August 4, 2015

Re: Response to Permit Review Comments, BP#2015-01369 767 Congress St.

Response to Comments:

Sheet Plot Date: 06/10/2015 A3\_0\_767Congress\_2ndFlr.dwg  
Sheet Number: A3.0

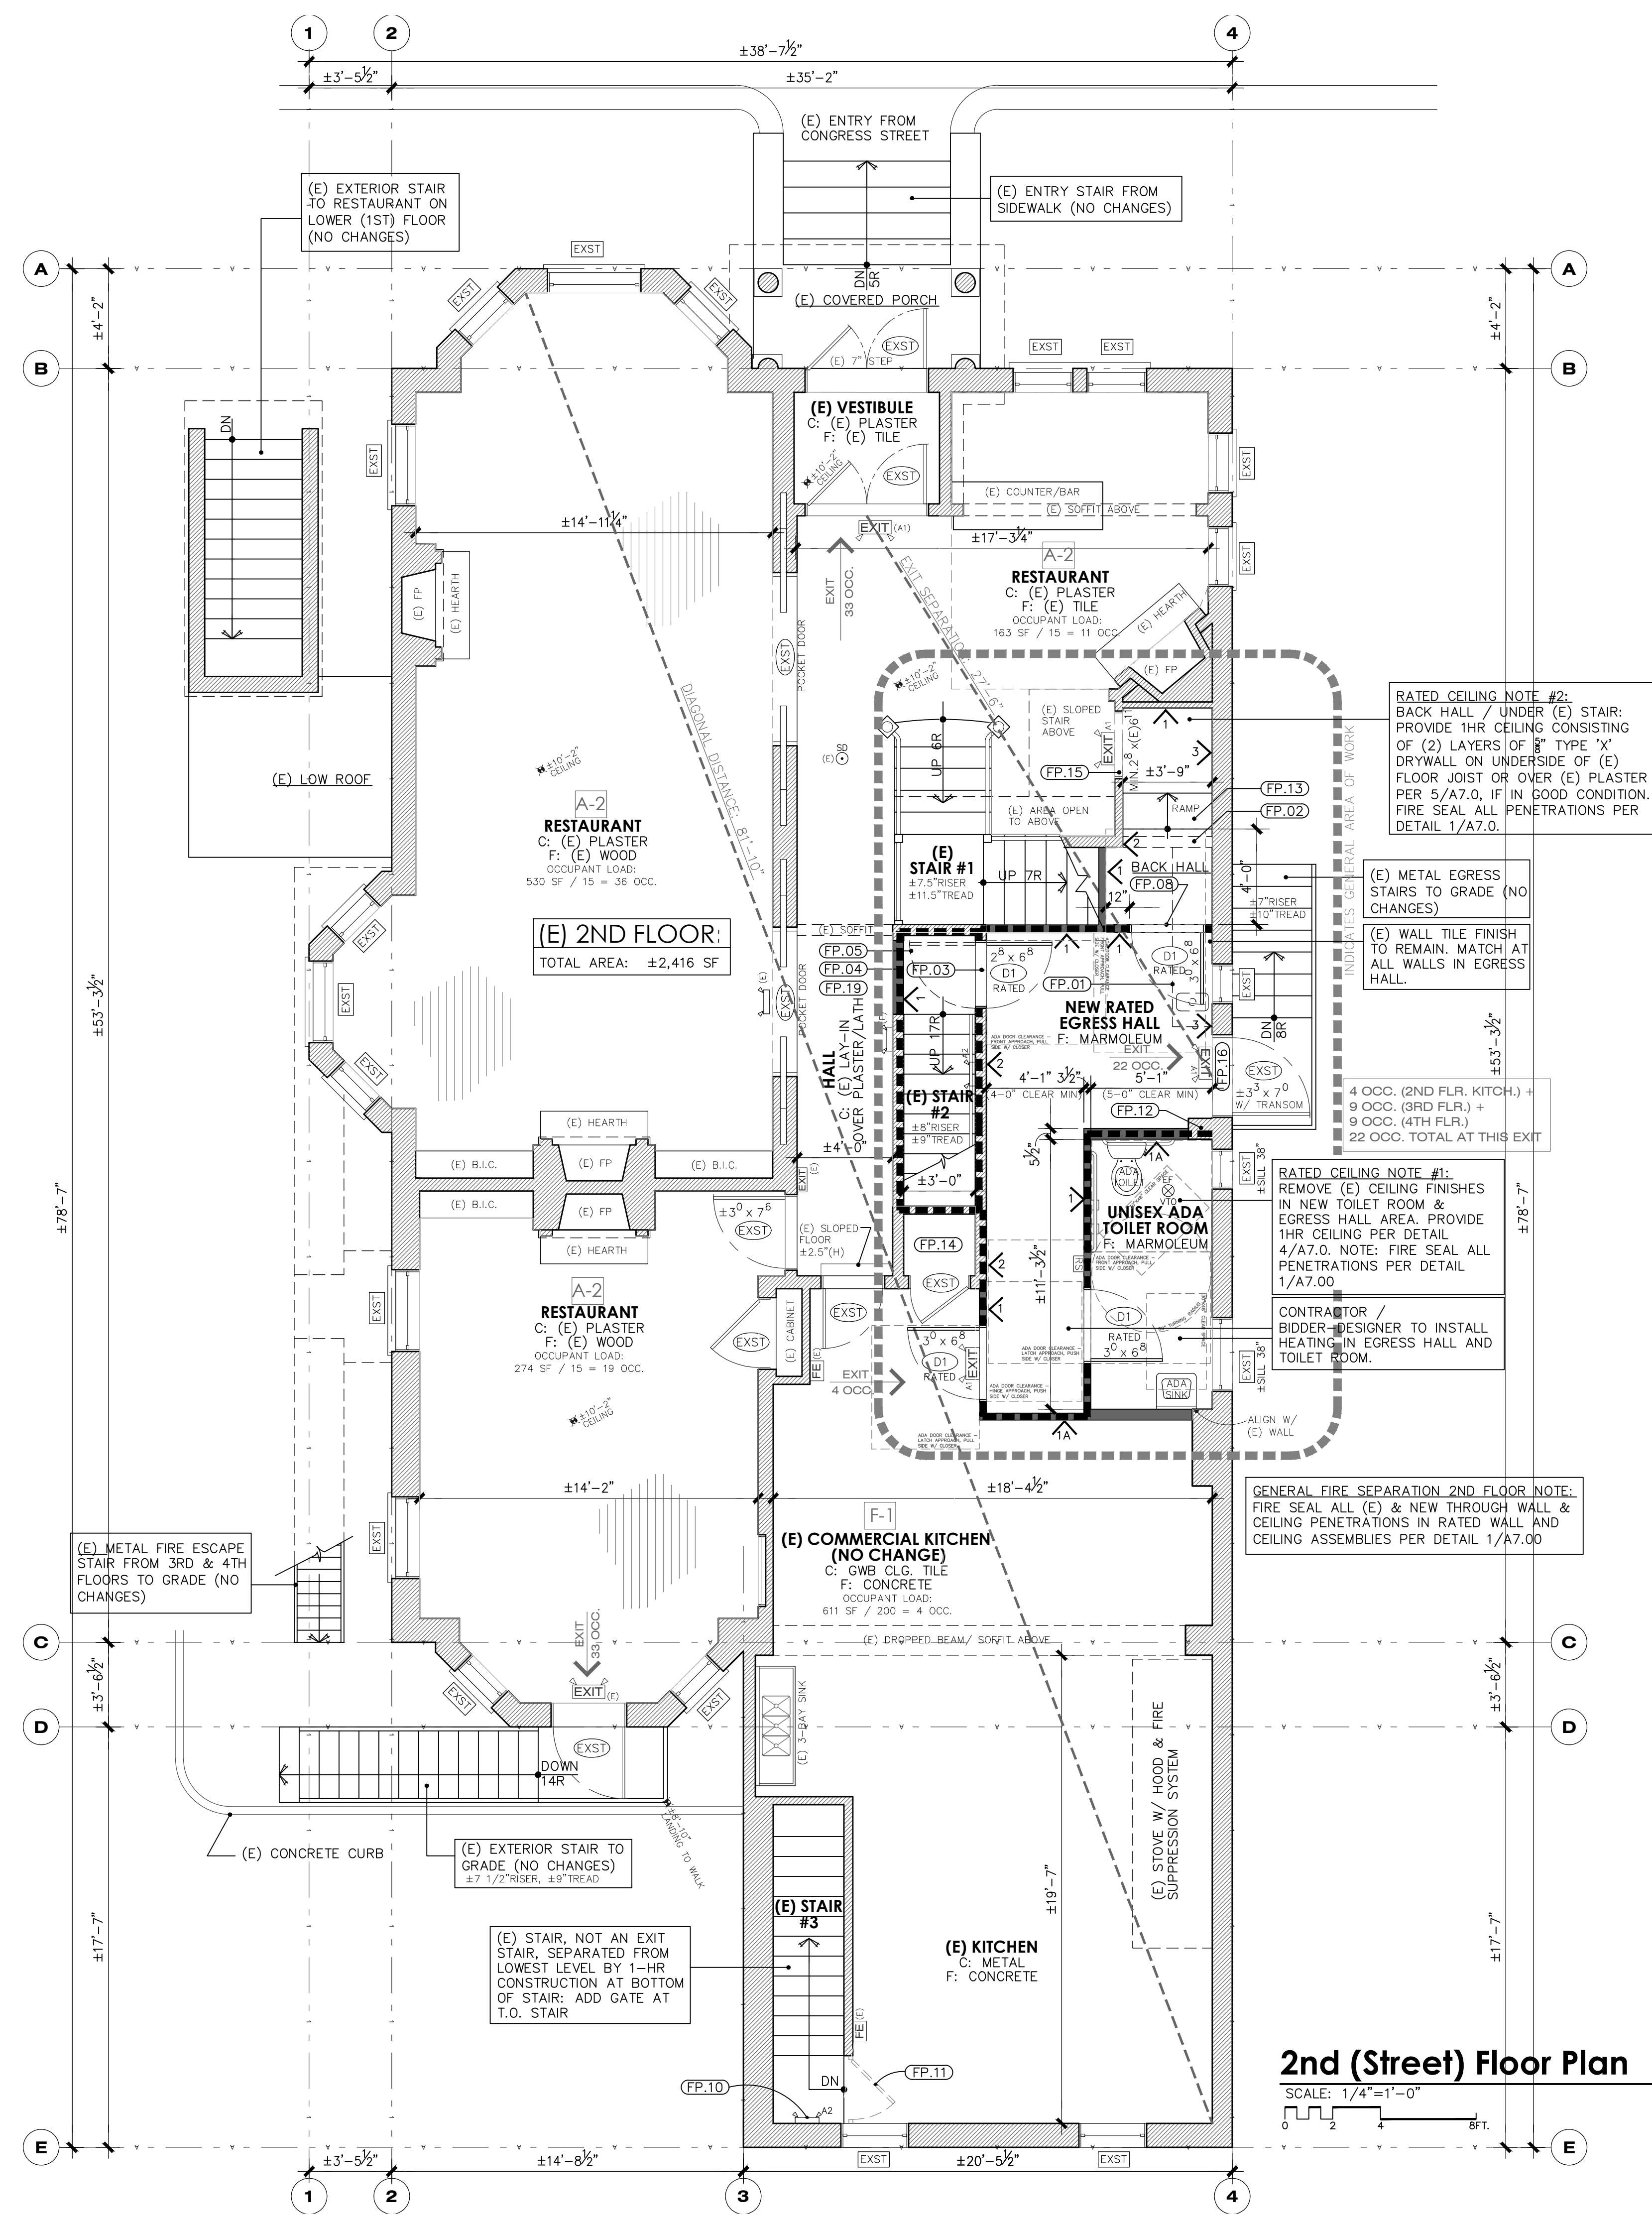
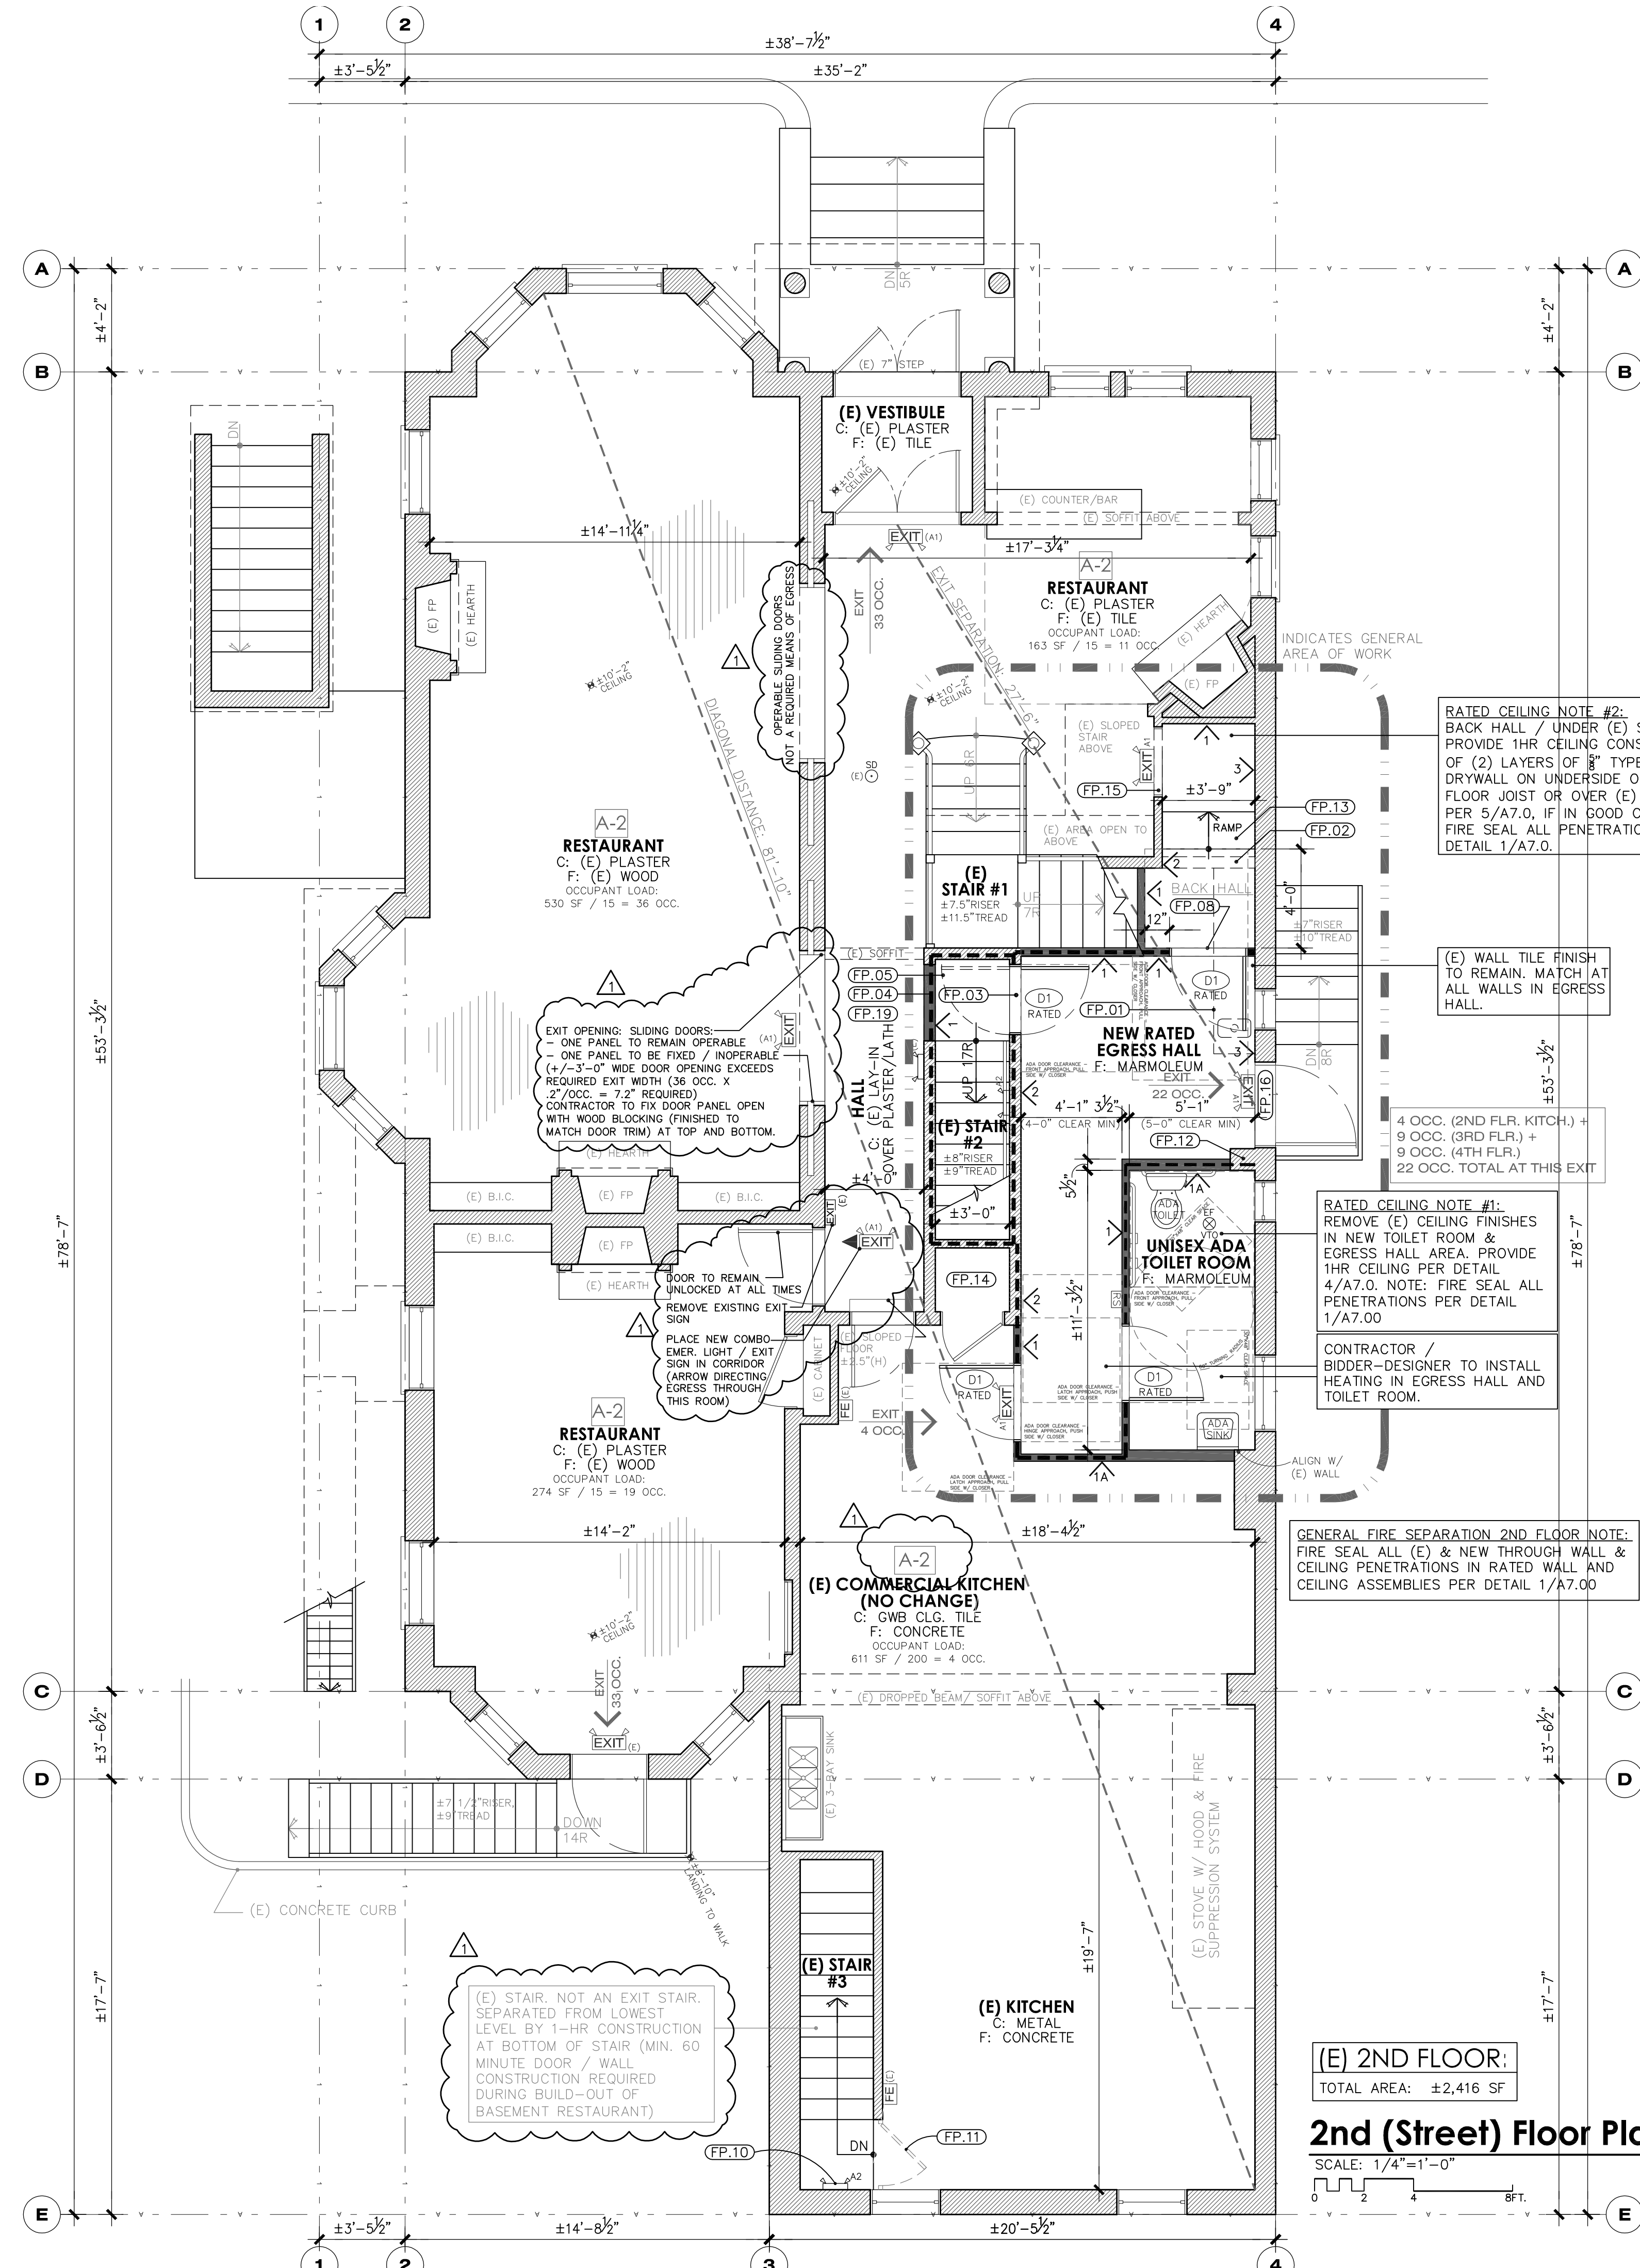
- **Comment:** *"Given this is a commercial kitchen and not food processing, this would just be considered an A-2 assembly. The occupant load calculation would break down the use of each individual space."*

- **Response:** "General Code Summary / Overview" and note on floor plan have been revised to reflect the A-2 occupancy category.
- **Comment:** *"Per Section 1008.1.4.3 horizontal sliding door, there are 8 criteria sliding doors must comply with. Please address and revise."*

- **Modifications requested at 7/31/15 site visit with David Petrucci:**
  - **Kitchen Storage (Under Stair):** Requested that we provide either an additional layer of 5/8" Type 'X' GWB or a sprinkler head in this closet. Drawings have been noted as such.
  - **Exit Light Location:** Requested that exit sign be added in hallway (near kitchen door) to direct occupants to rear exit door. See floor plan for sign location and notes.

- **Response:** See revised sheet A3.0. Section 1008.1.4.3 refers to doors used as means of egress. Due to low occupant load, only one door width will be required for exiting. We propose that one door leaf will be fixed open (location shown on plan). All others to remain operable.
